Your Ref: OWPC1820
Our Ref: AW/331/13/ 03-12-2013
Please ask for:
Mrs J Chapman

Extensions, structural alterations, balcony & carport
3 Shorecroft Bognor Regis

Thank you for your internet representation made on 15th January 2014 which has been recorded as '**an objection**' with the comments as follows:

Site Plan
Existing and
Proposed

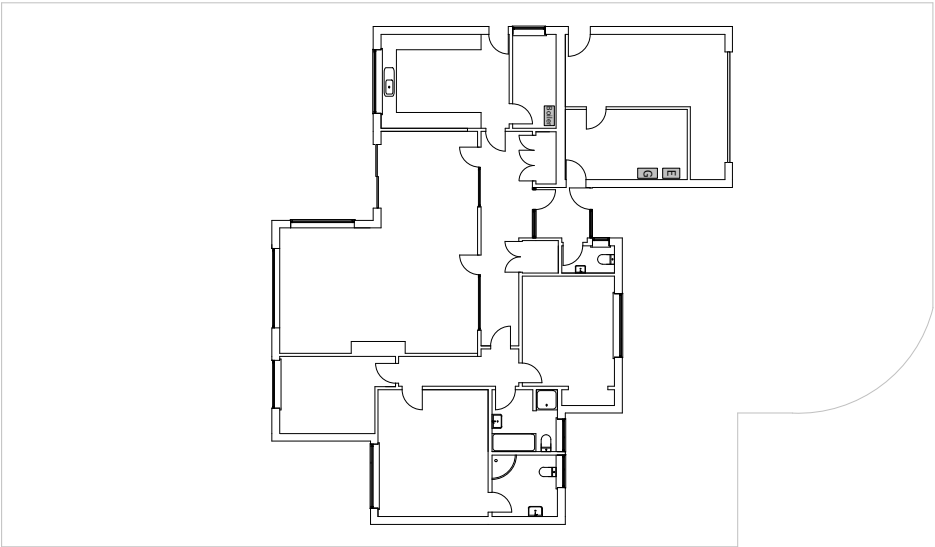
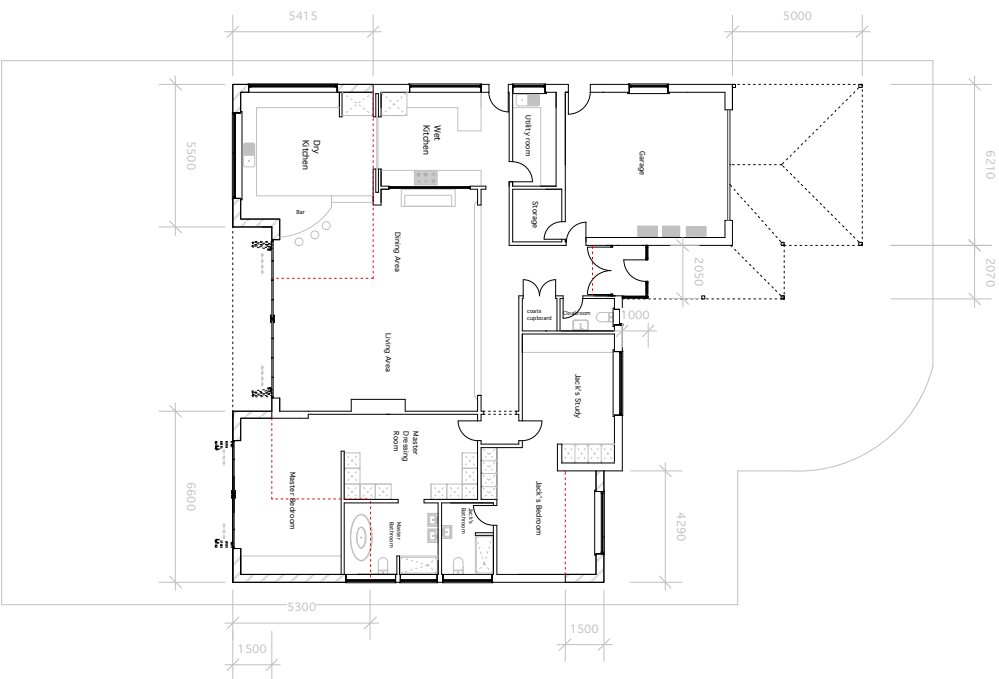
3) Car port will be more intrusive to the eye coming forward to the road. If the screening hedge is removed then car port will stand out without any screening. It appears that the construction will be right out to the very edge of the building line in other words protrude out beyond anything else on the site. At the moment any car parked on the drive is screened by the large hedge on the west side of the site. What will happen to the screening scrubs in the front of the bungalow? Their removal will make the parked cars even more unsightly.
